**KIRKLEES METROPOLITAN COUNCIL
INVESTMENT & REGENERATION SERVICE**

Reference No: 2017/62/90978/W

Site Address: 8, Beagle Avenue, Beaumont Park, Huddersfield, HD4
7AP

Description: Erection of two storey and single storey side
extensions

DRAWING 4 – PROPOSED FLOOR PLANS

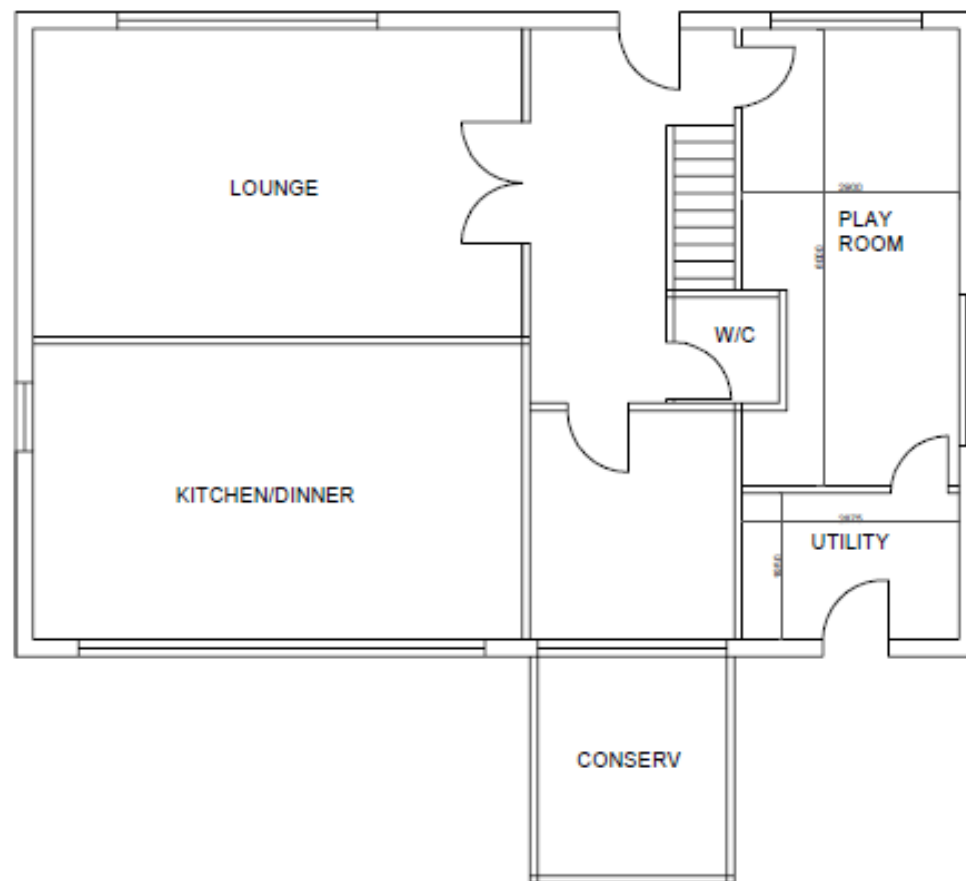
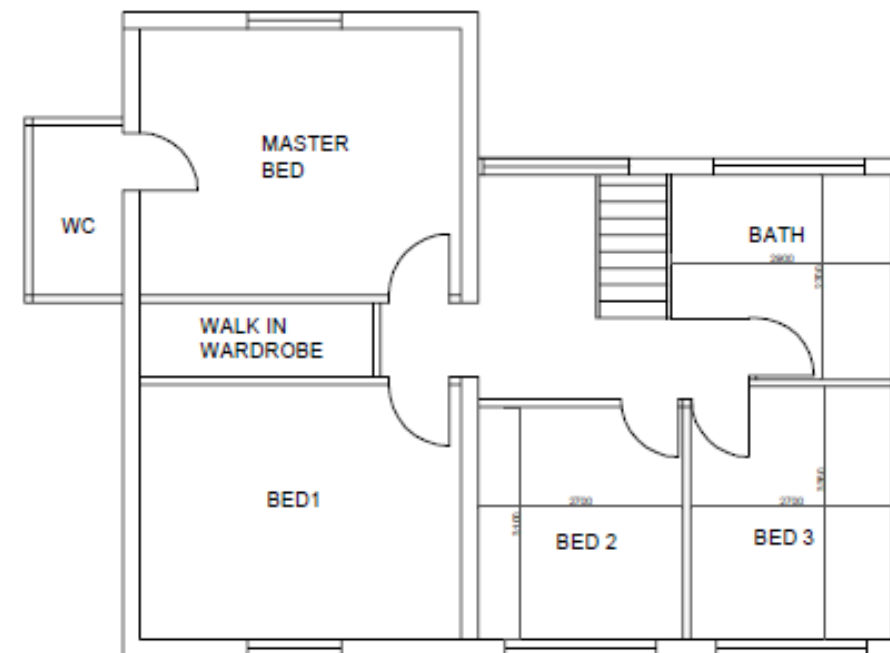
10. With regards to the opening within the front elevation, there are already habitable room windows at both ground and first floor level. The proposed openings would be to a playroom and entrance at ground floor and a bedroom and landing at first floor. Whilst noting that additional habitable room opening would be created, these would not decrease the established separation distances between the site and the facing dwellings which is a distance of approximately 30 metres, which is considered to be acceptable.

In terms of the rear elevation windows, an additional 2 no. bedroom windows would be created along the same building line as the existing bedroom window. Again, there would be no decrease in separation distance which is established also at approximately 30 metres. Concerns have been raised regarding overlooking from the creation of the new openings however when put into context in terms of a new dwelling, should a new build be proposed, Policy guidelines state that separation distances between established properties and new dwellings should be a minimum of 21 metres. As the proposed distances exceed in this requirement, it is considered that the proposed openings are considered to be acceptable. A first floor window is also proposed within the side elevation of the extension facing No. 10. As this would be to a WC, it is expected that this would be obscurely glazed which can be controlled by an appropriate condition.

- 3. The development shall not be occupied until the first floor window in the side elevation of the extension facing No. 10 Beagle Avenue of the extension hereby approved has been fitted with obscure glazing, minimum grade 4. Notwithstanding the provisions of section 55(2)(a)(ii) of the Town and Country Planning Act 1990 and the Town and Country Planning (General Permitted Development) Order 2015 (or any Order revoking or re-enacting that Order with or without modification) the window shall thereafter be so retained obscure glazed.
